ENG-PUDSP21002-R2-PUDSP.pdf Markup Summary

SITE PLAN

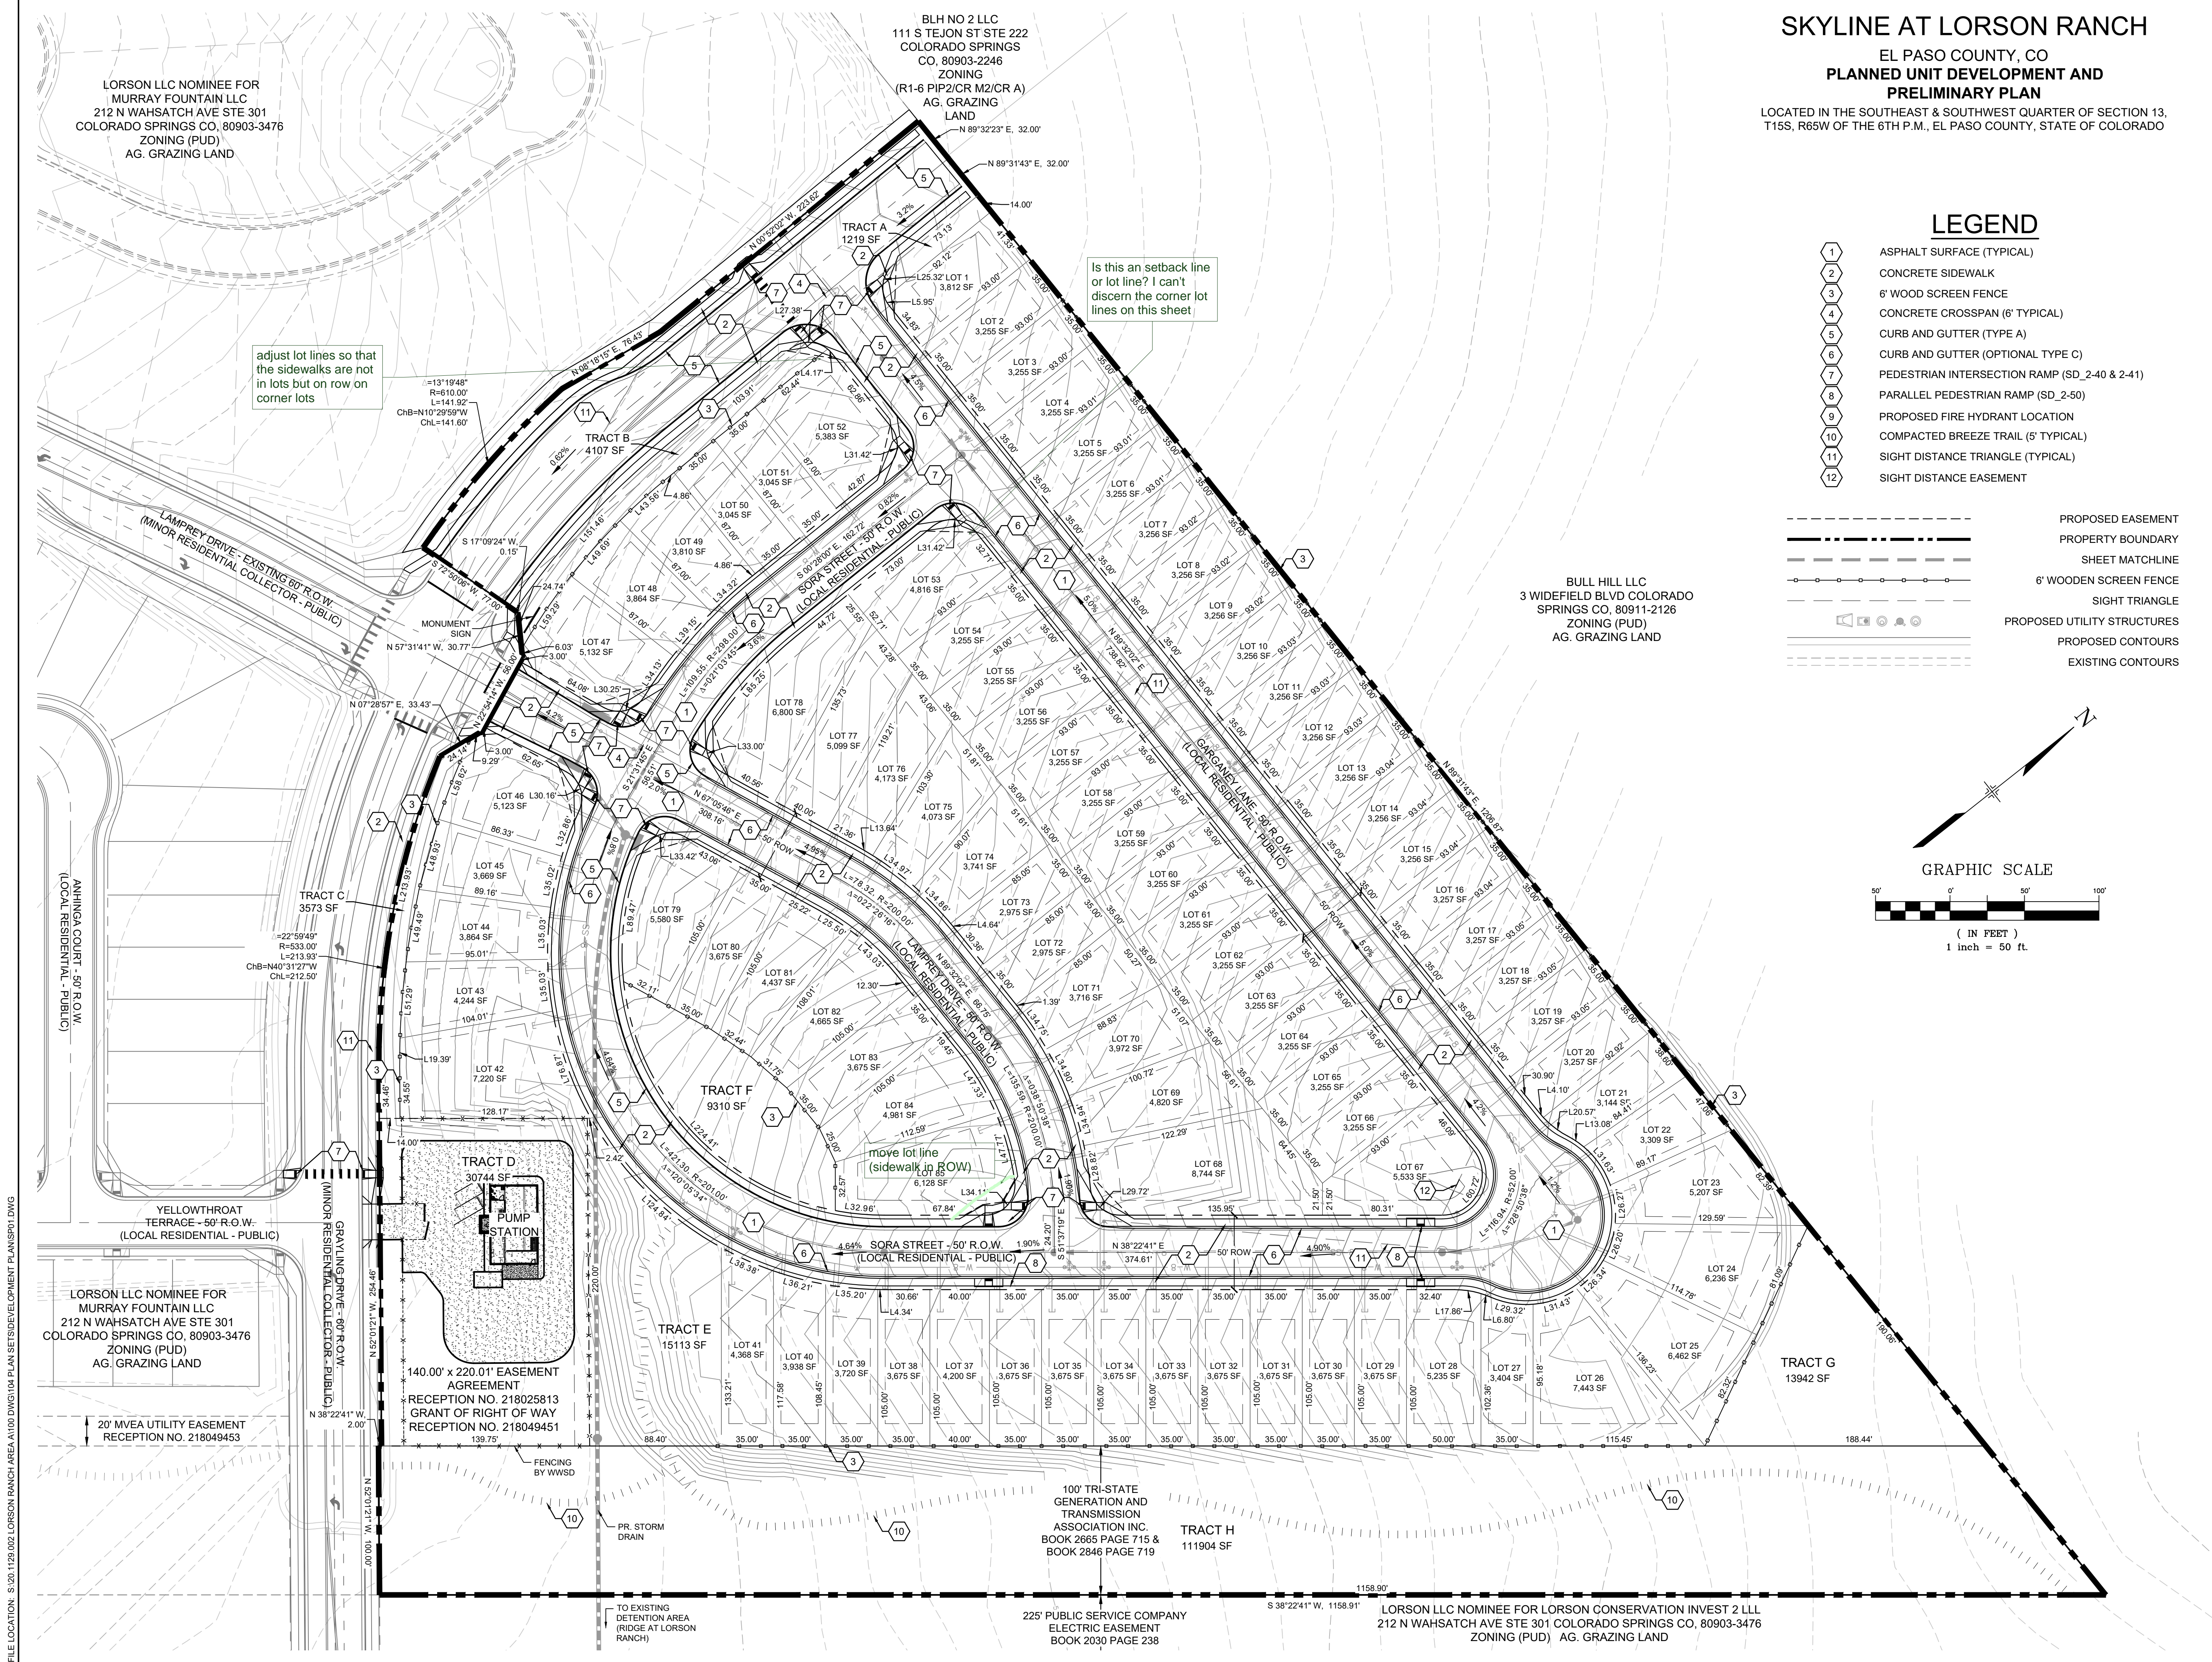
Subject: Callout
Page Index: 4
Date: 7/29/2021 3:57:17 PM
Author: dsdparsons
Color: ■
Layer:
Space:

show the retaining walls over 4 feet because they are req to obtain building permits so we want to make sure that they are depicted so setbacks re not an issue/ provide detail of wall; also who is to maintain those?

Fences shall not block sight distance triangles.

Adjust corner lots so that sidewalk is not within the lots.

Wall needs to be behind the sight distance line.

Subject: Callout
Page Index: 4
Date: 8/6/2021 9:10:59 AM
Author: dsdrice
Color: ■
Layer:
Space:

Adjust corner lots so that sidewalk is within the ROW.

Add a label regarding the detention basin.

Place fencing behind sight distance line
